**MAJOR PROJECT ASSESSEMENT:  
Macquarie University Private Hospital  
Major Project No. 06\_0172**

Director-General's  
Environmental Assessment Report  
Section 75I of the *Environmental Planning and  
Assessment Act 1979*

May 2007

EAST ELEVATION

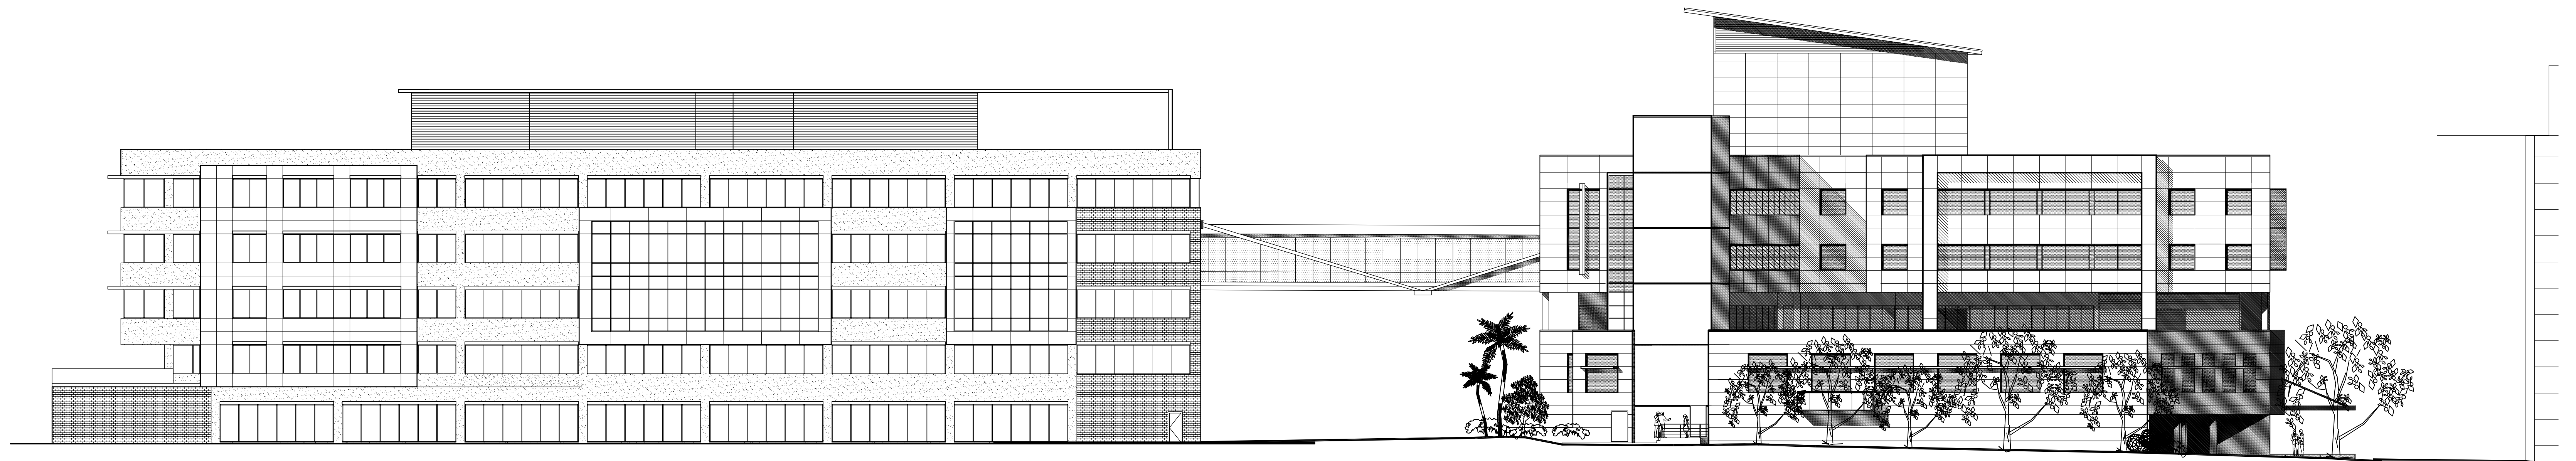
The proposed Talavera Road setback encroaches on the 15m setback established on adjoining properties.

The proposed development has a 5m setback for the first storey, a 9m setback for the second and third storeys and a 17m (minimum) setback for the remaining storeys above. Figure 9 illustrates an artists impression of the proposed Talavera Road set back.

It is considered that the 5m setback along Talavera Road is inadequate and will have an adverse visual impact on the streetscape. The 5m setback will be unable to support sufficient deep soil planting as the basement car park extends to within 2m of the site boundary. This section of Talavera Road also has a number of advanced eucalypt trees worthy of retention. The existing setback along this portion of Talavera Road is demonstrated below at Figure 10.

The Department recommends increasing the Talavera Road setback to 9m to reduce the visual dominance of the building within the streetscape. Increasing the setback to 9m will effectively delete the proposed colonnade and a minor portion of the basement below. It will require relocation of the existing plant rooms by about 4.5m. This will result in the loss of about 10 car parking spaces. Deleting this portion of the building will not impact upon the GFA

It is therefore considered reasonable to impose a condition of approval which imposes a 9m setback along Talavera Road to provide for the retention of existing trees contained within the setback.
